**The Long House, Main Street, Sibford Ferris,  
Banbury, OX15 5RG**

**22/03145/F**

**Proposal:** Installation of ground based solar panels with a total surface area of 18 square metres

08A

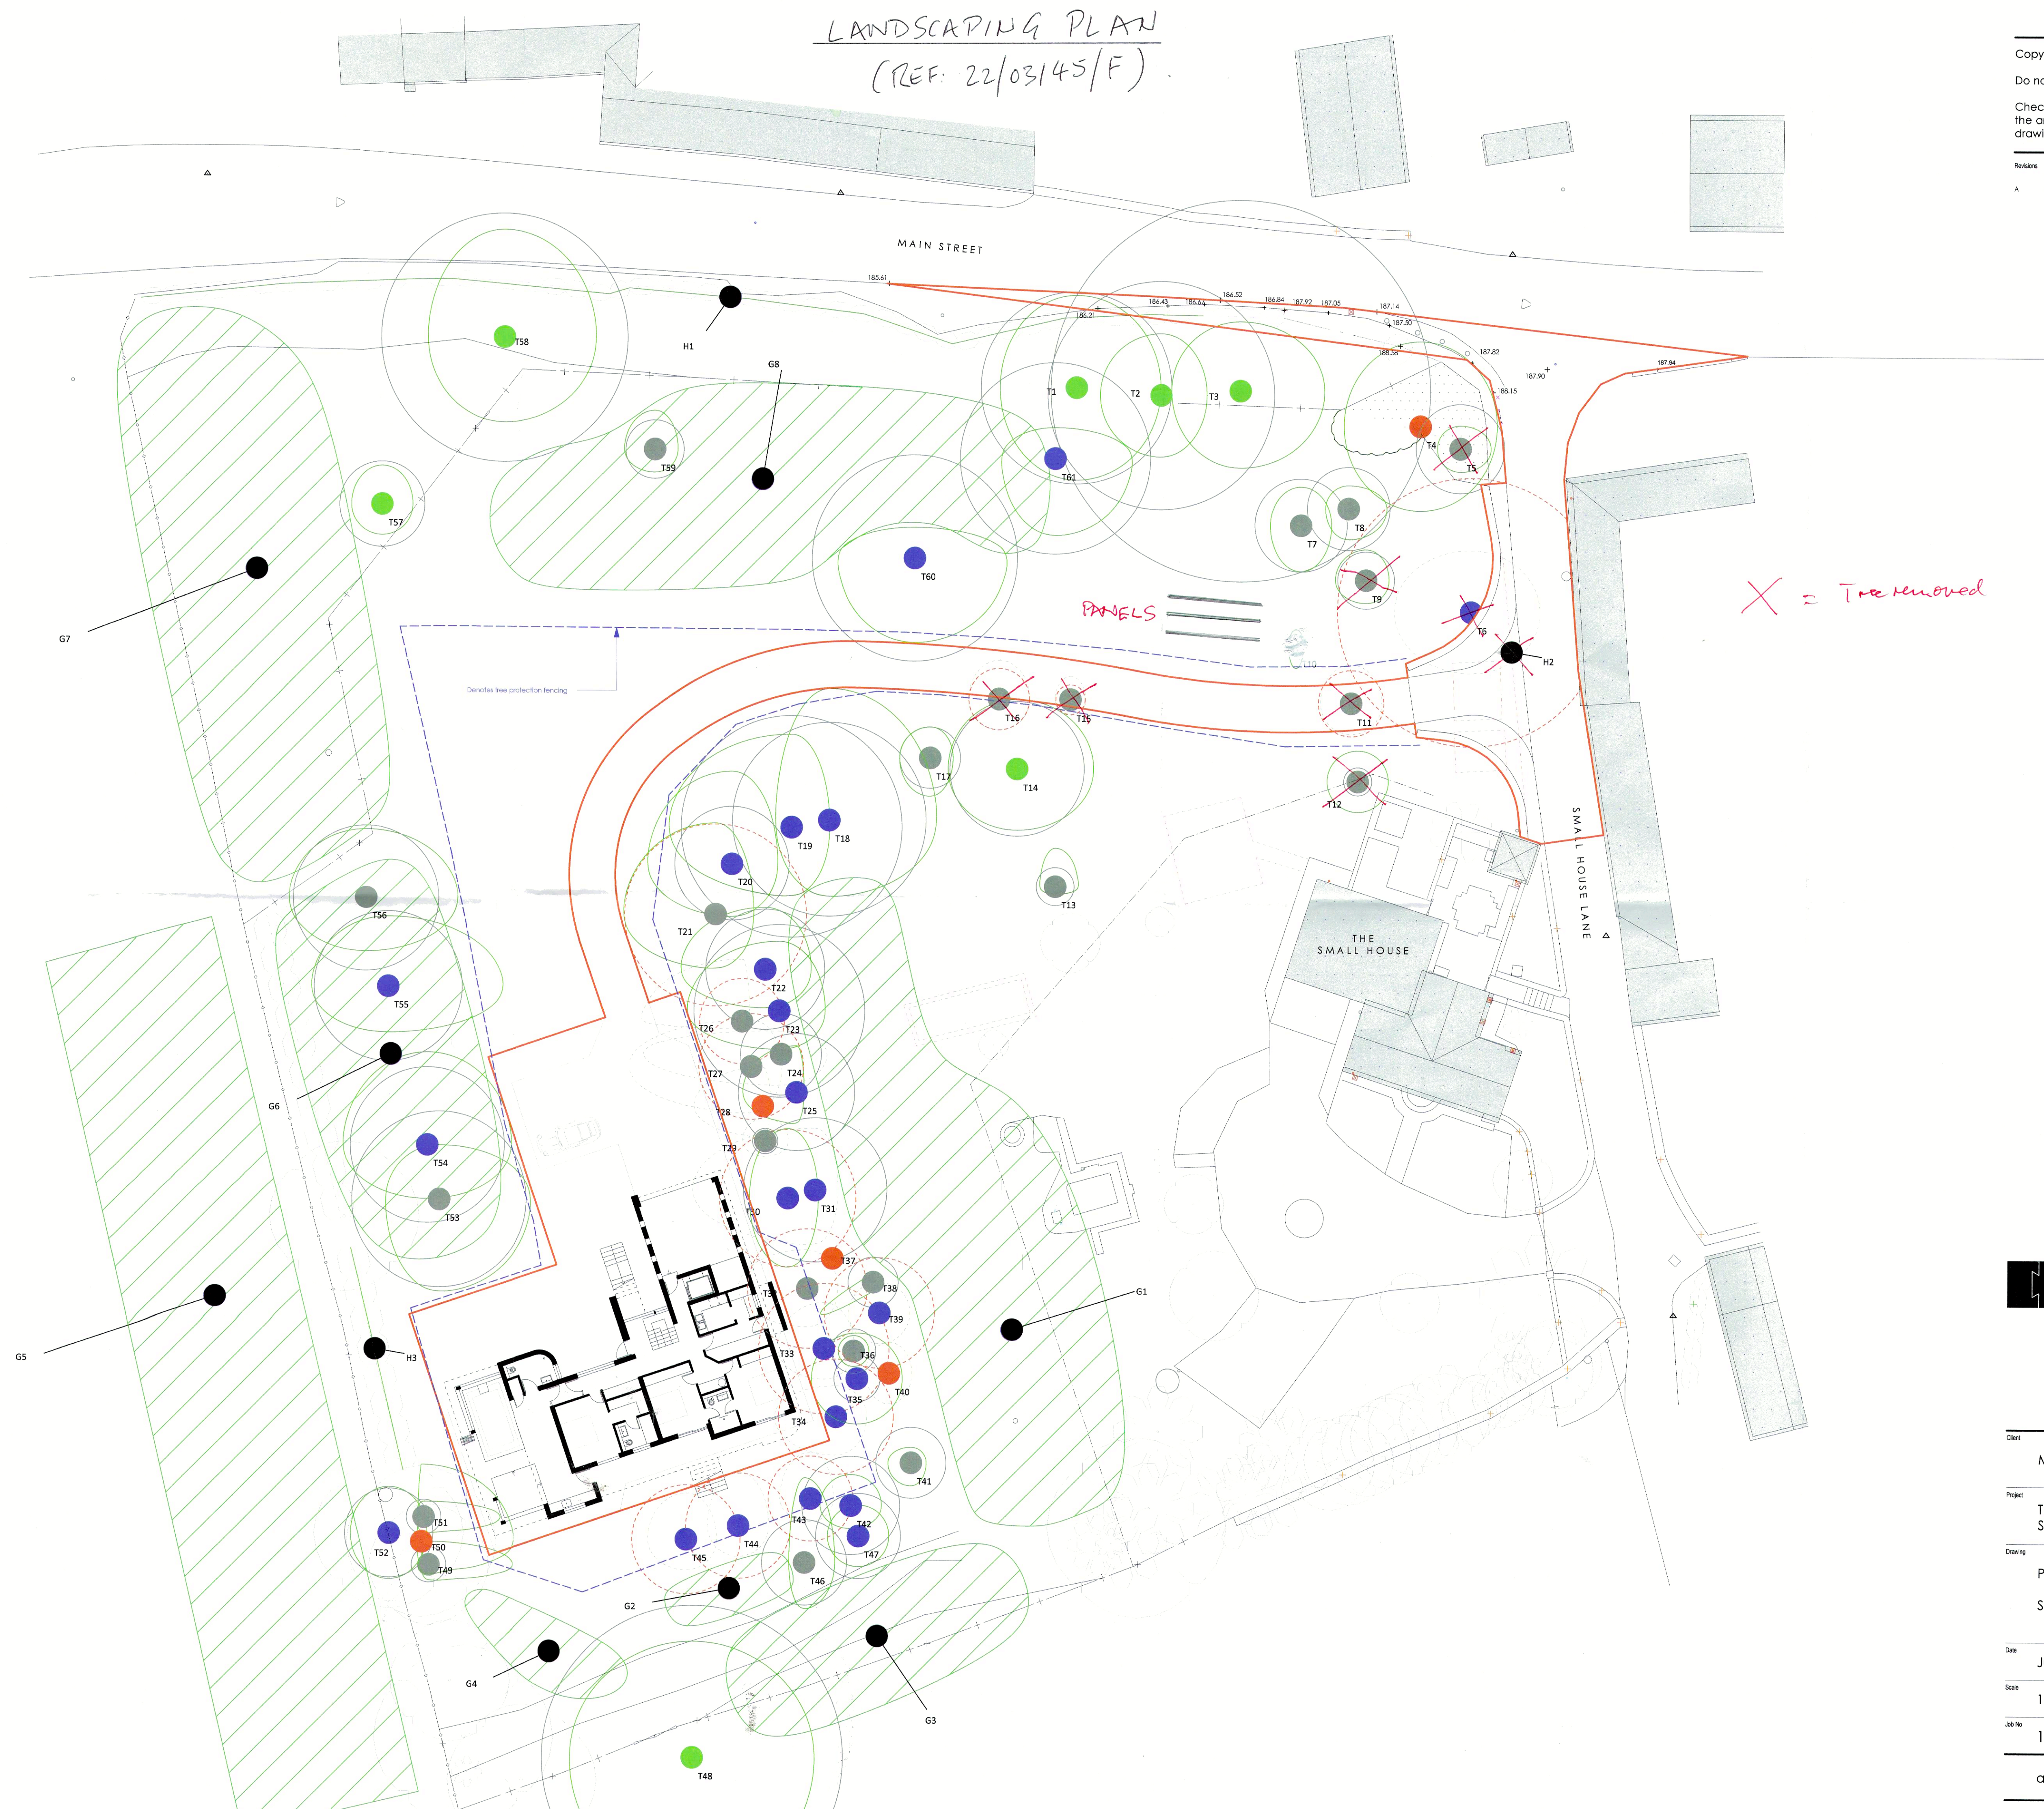
- 8.21. The Arboricultural Officer (AO) raised no objections to the principle of the proposal but had concerns with regards to a tree removal plan, proposed trees to be removed and accuracy of the plan of the proposed solar panels.

- 8.22. The applicant responded confirming that the access way and associated tree works were completed in 2016, that no trees would be removed or affected in completing this small solar panel installation, the crown of the tree to the north of the installation would not need to be pruned back, a small amount of overhanging from a tree to the North would not have an impact and stating the panels on the plan are drawn to scale.

- 8.23. The AO responded to the applicant's comments advising that comments from the applicant addresses the initial queries raised. Having regards to AO comments, it is considered that the proposal would not result in harm to the existing trees or vegetation in the vicinity of the site.
